**Consultation Response from KC,
Lead Local Flood Authority**
2026/90232 New Mills, Brougham Road, Marsden, Huddersfield, HD7 6AZ

Date Responded: 12/05/2026
Responding Officer: Martin Stephenson
Responding Ref: 1
Documents reviewed by the LLFA:

- 23421-DCE-XX-XX-D-C-100, Drainage Strategy, Rev P03 dated 03/12/2025.
- 23421-DCE-XX-XX-D-C-129, Flood Exceedance Route, Rev P03 dated 03/12/2025.
- 23421-DCE-XX-XX-T-C-002, FRA & Drainage Strategy, Rev P03 dated 14/01/2026.

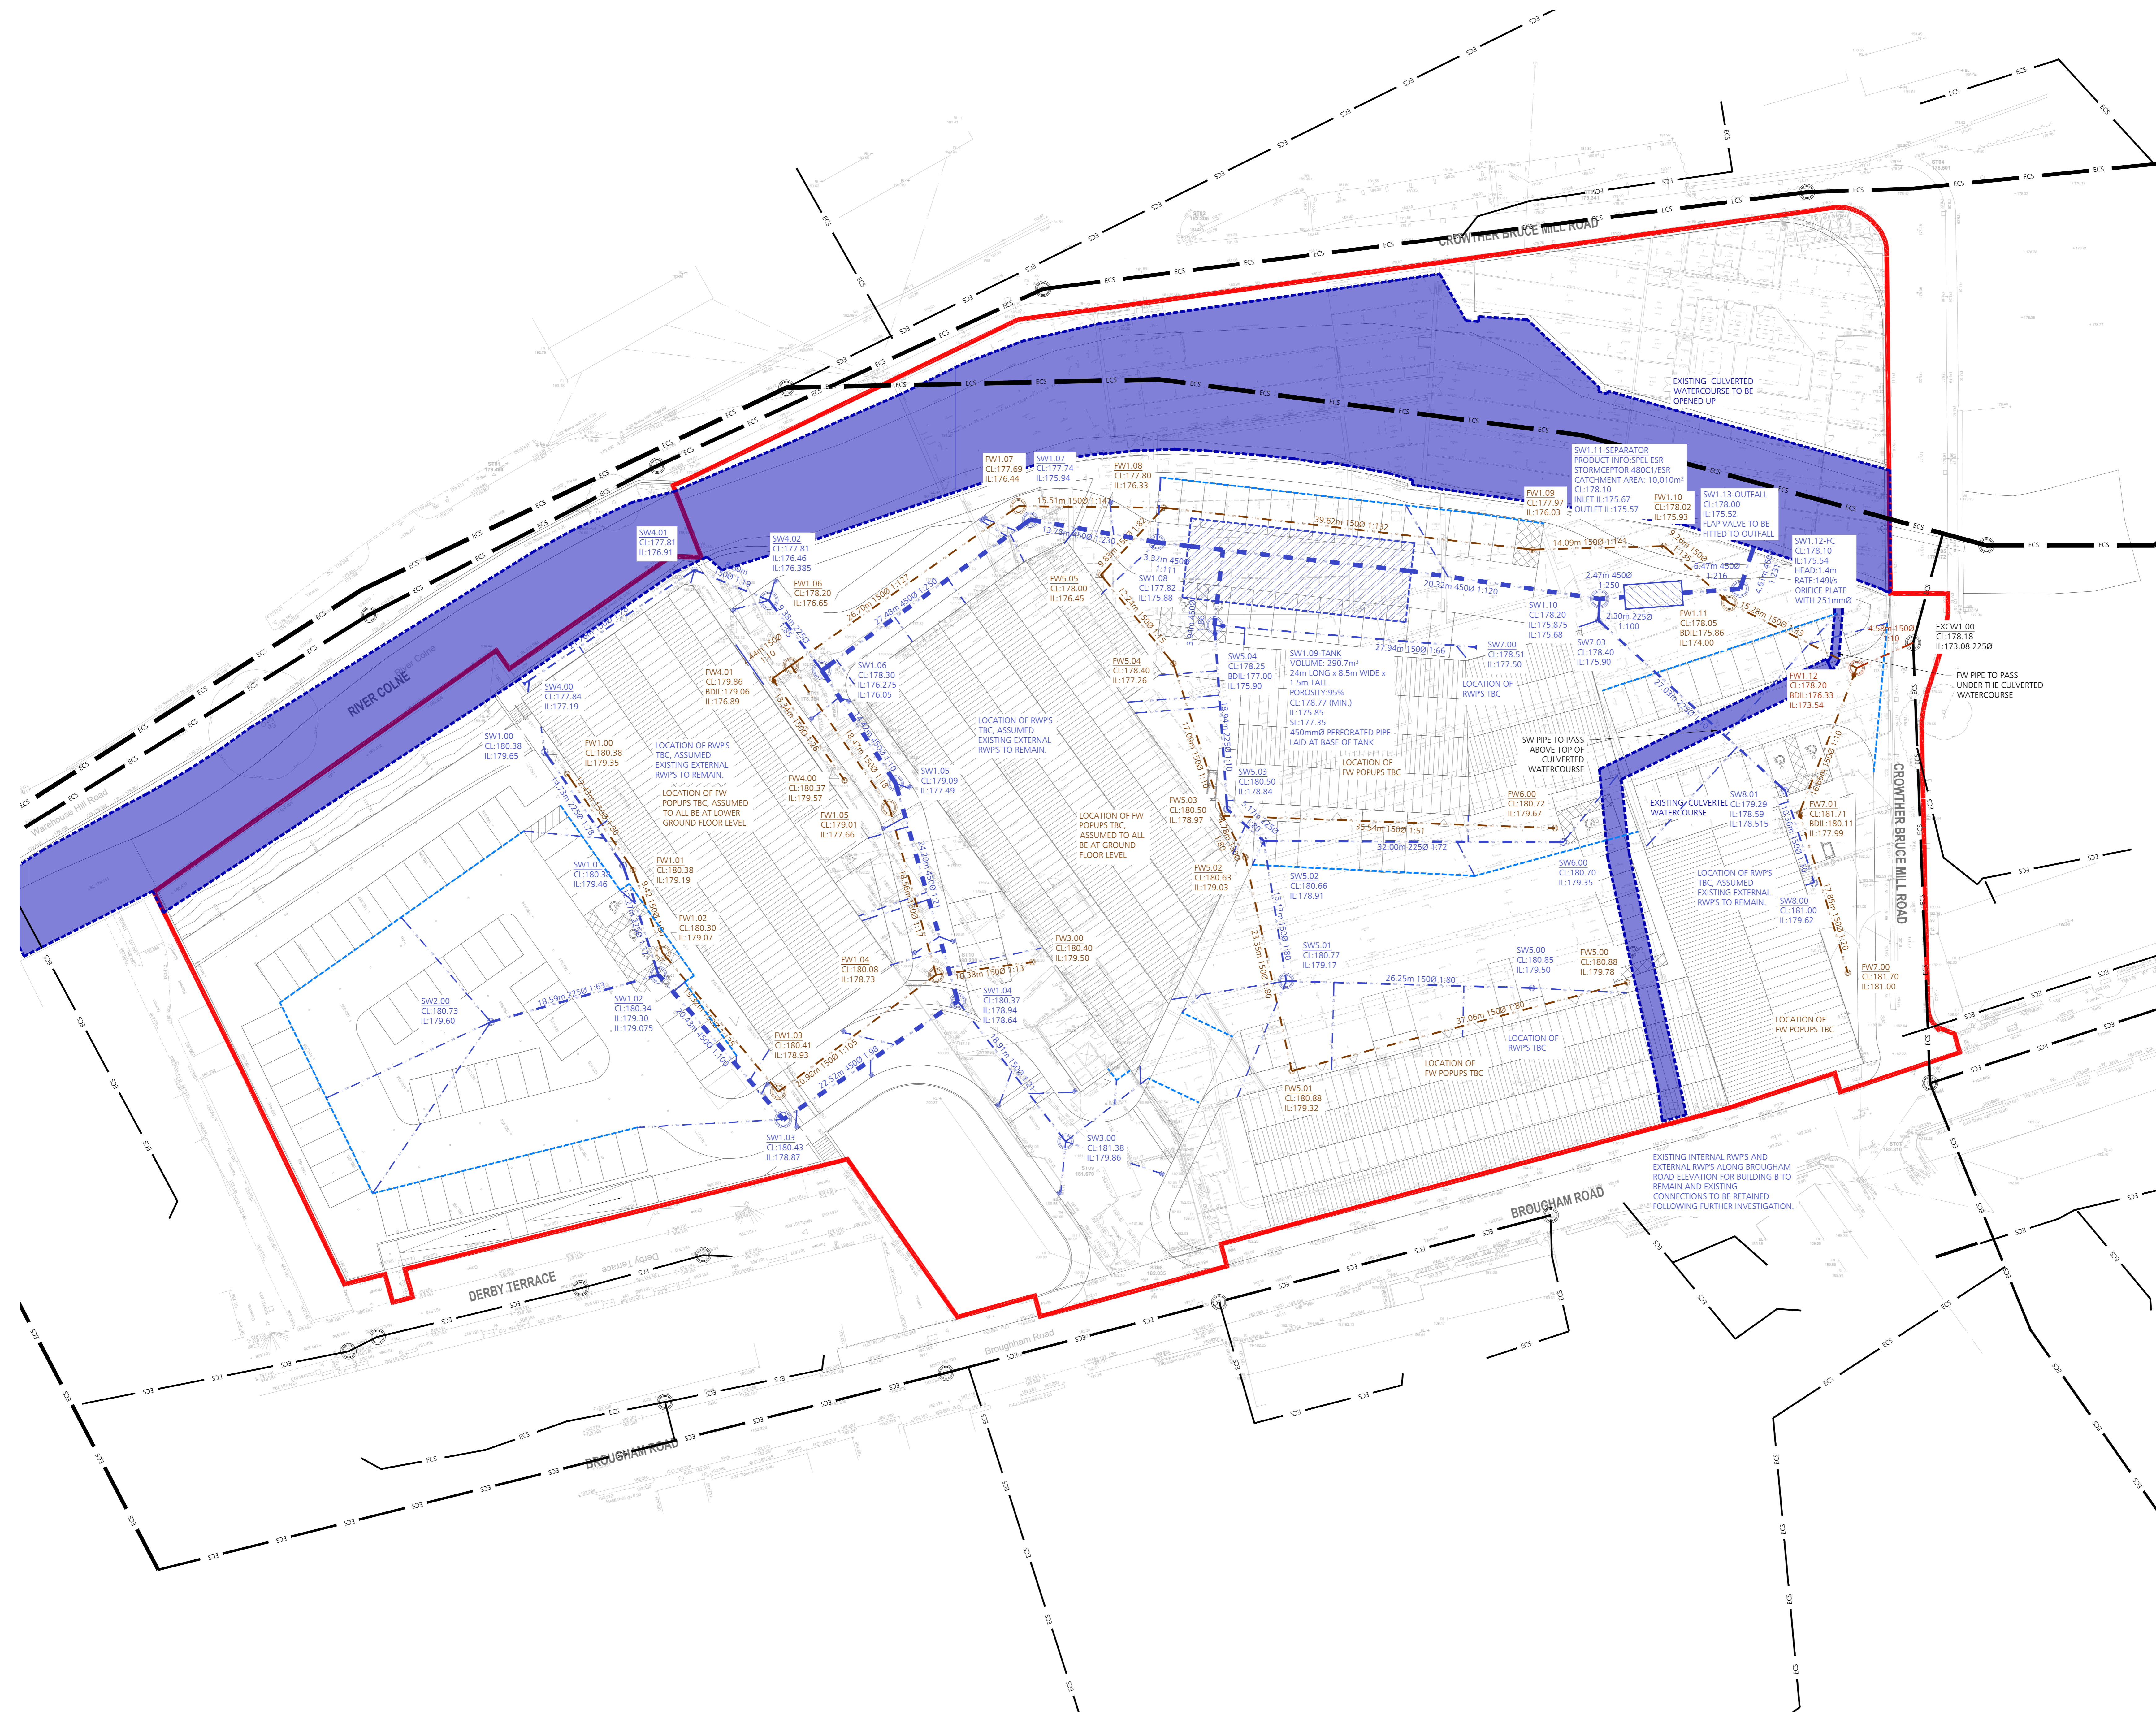
The LLFA also accepts the proposed surface water discharge rate of **149l/s** into the river Colne as indicated on the Drainage Strategy drawing, however the LLFA would prefer that the flow control device is of the vortex type (e.g. HydroBrake) rather than an orifice plate as these are less prone to blockages and have a better flow vs head performance at lower flow rates.

The LLFA also accepts the proposed geocell type attenuation tank with a low flow perforated pipe in its base, however the upstream MHs (SW1.08 & SW5.04) should be of the silt trap type to reduce the risk of siltation within the tank.

It is noted that the CL of MH SW1.08 (177.82) is 0.95m lower than the minimum CL of adjacent Attenuation Tank (178.77) and only 0.47 above the Tank's SL (177.35). The developer is requested to review the site GLs in the vicinity of the Tank to ensure there is adequate cover to the tank in accordance with the tank manufacturer's recommendations.

Generally, rainwater run-off should not be discharged through an oil separator to prevent the flushing out of oil in heavy rainfall, however the LLFA understands separation of the RWP drainage from the hardstanding drainage is difficult with a constrained site. The LLFA requests that consideration be given to draining the two parking areas (East Mill Car Park and the one at the site entrance) and the slot drain across the entrance directly to the oil separator on a dedicated drainage system excluding RWP drainage (if possible).
